Response to Planning Application

Application ref: A/102/22/PL

Description: 1 No new dwelling. This application is a Departure from the Development Plan and is in CIL Zone 3 and is CIL Liable as new dwelling.

Location: Land rear of Oakhurst House and Huntington House West Drive Angmering

SITE LAYOUT PLAN AS PROPOSED

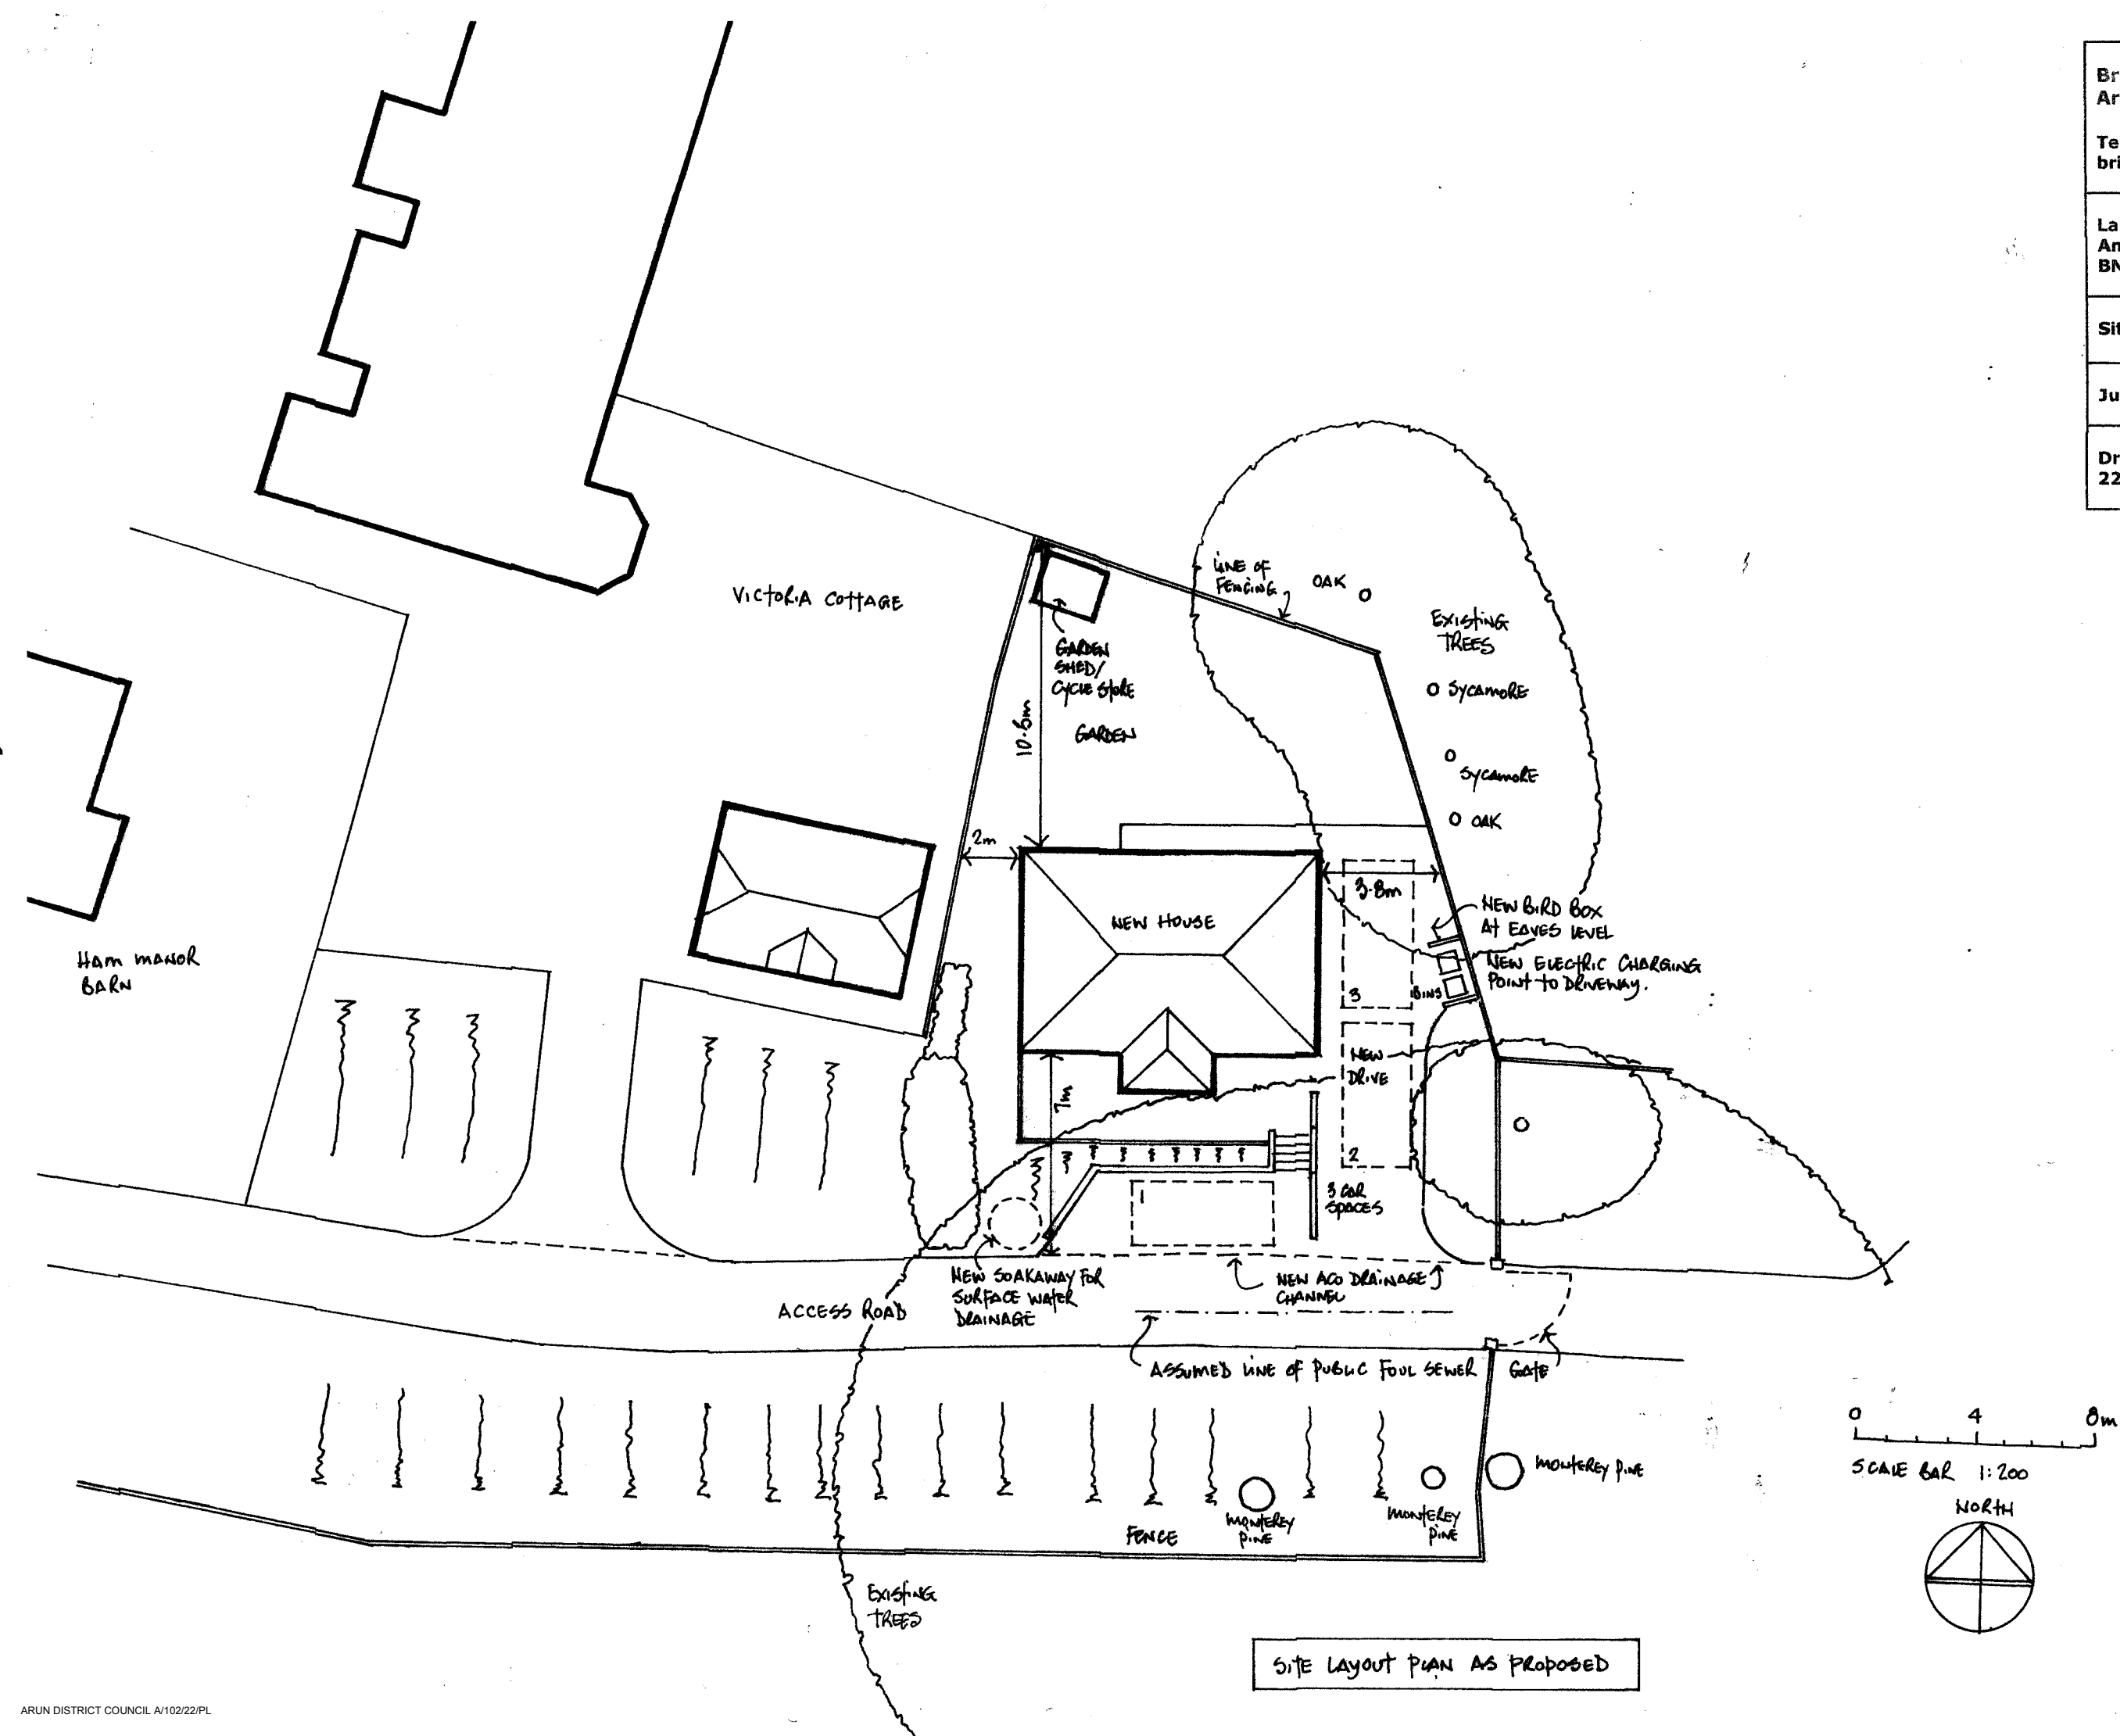
It is unclear from the submission the extent of clearance works and potential vegetation removal works required to undertake the proposed build.

The NPPF para 124/127 relate to good design principles which equally apply to small infill and replacement development. The indicative site layouts has shown the adjacent offsite trees but no indication has been made re new or screen landscaping. These details would require submission in the form of a detailed planting plan and specification detailing species choice, actual plant quantities, planting densities and size at time of planting. Detail should also be provided regarding existing trees and boundary planting.

In order for the proposals to blend into this location in relation to its setting and the adjoining dwellings then a landscape scheme will need to be detailed, be appropriate for setting and provide screening as required.

A full landscape scheme will need to be submitted for approval, or conditioned as part of any approval; detailing species choice, position, densities and size at time of planting. This should be plotted in plan and list form and in relation to the trees and vegetation to be retained so that a clear picture of the proposals can be seen. These details are required to ensure that appropriate mitigation is provided, maintaining and

Recommend **no landscape objection** to the proposals, subject to the submission for approval of a detailed landscape scheme as above.
